Pilar Aberasturi - RE: MP 09_0051 MOD 1 - S75W for Centre for Obesity, Diabetes and Cardiovascular Disease

As per our advice to the applicant at the meeting, in relation to the northern facade, the City prefers the architectural expression of the original design. The original design being the scheme the City provided comments on by letter dated 5 January.

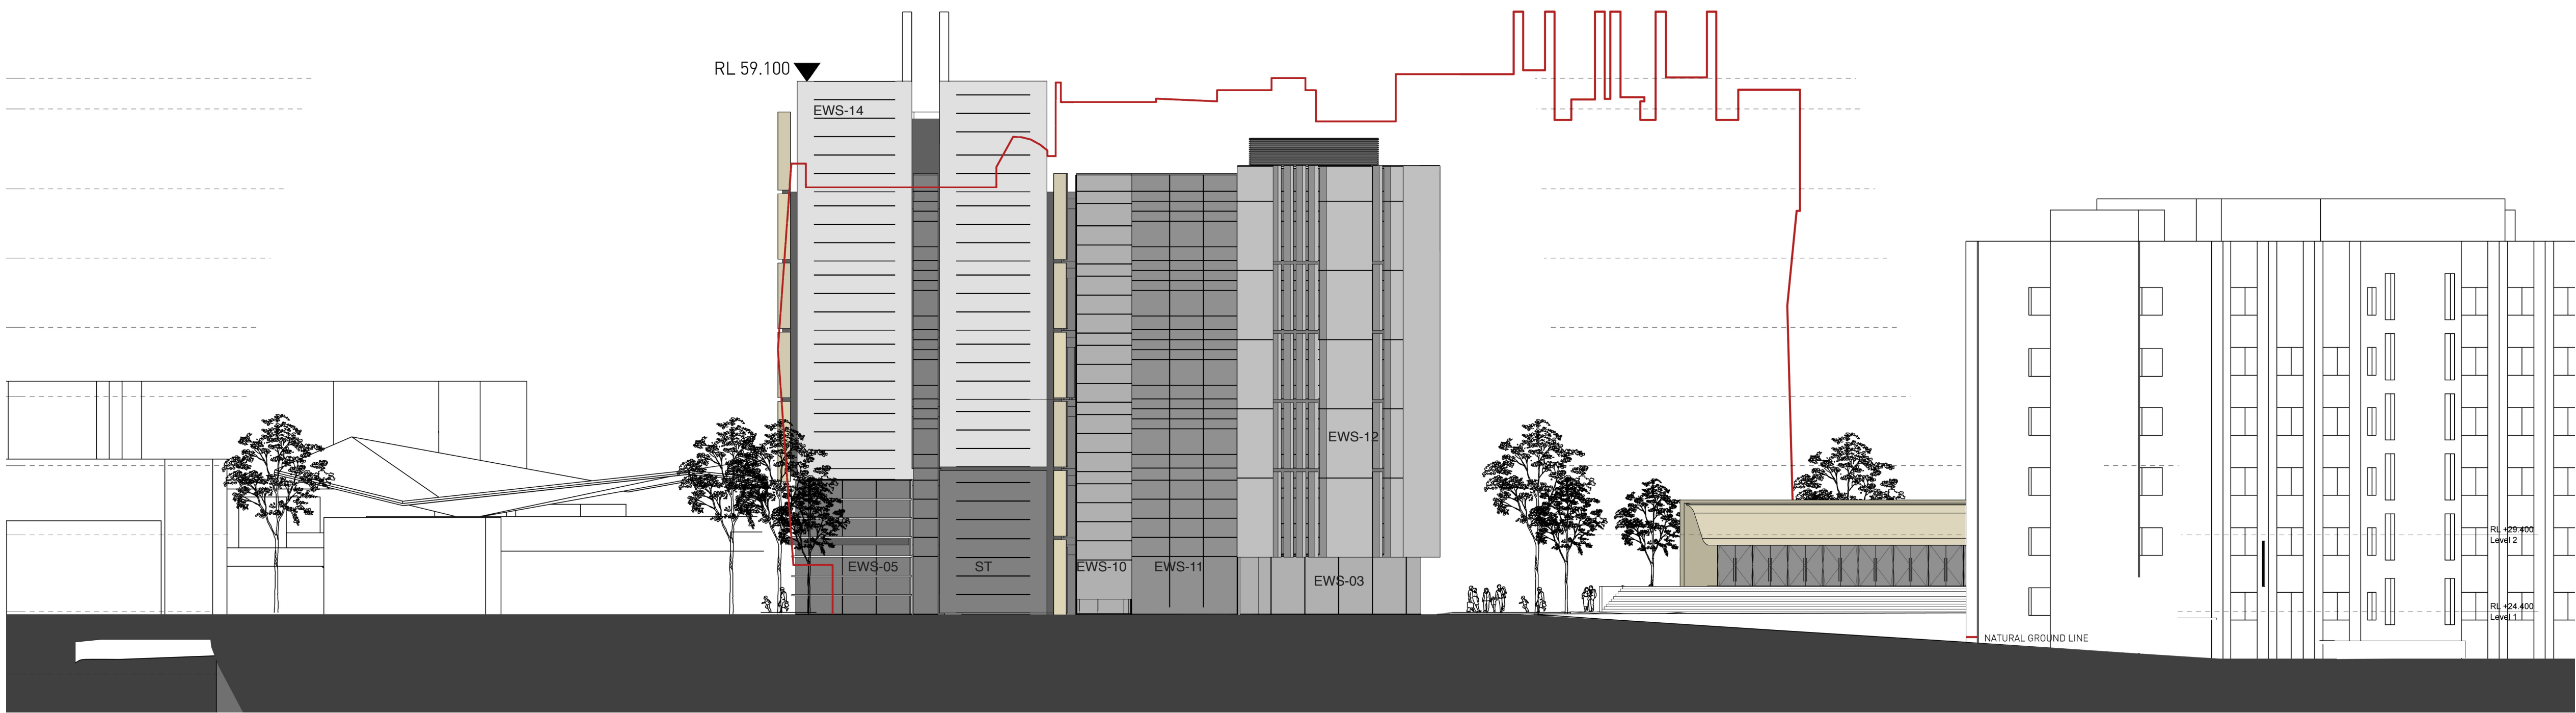
The original design is considered to better respond to its context through its proportions, the delineation and balance of horizontal and vertical divisions, and its solid to void relationship. The amended scheme is considered to diminish the strength and originality of the original design by its (different) proportions, the reduction in the size of the openings and the reduced use of sandstone. Despite the length of the building and the solid facade, the original design successfully reduced the apparent bulk through its simplicity, the repetitiveness of the design and materials which emphasised the horizontal, and the clear break about mid-way through the facade.

Overall, the original design is considered more successful because of its uniqueness and strength. The building's setting is rare, offering uninterrupted views of the entire northern facade from the north and west, across St John's oval and even potentially from Parramatta Road. The original design is considered a more distinct response to this setting and is also considered more sympathetic to St John's College.
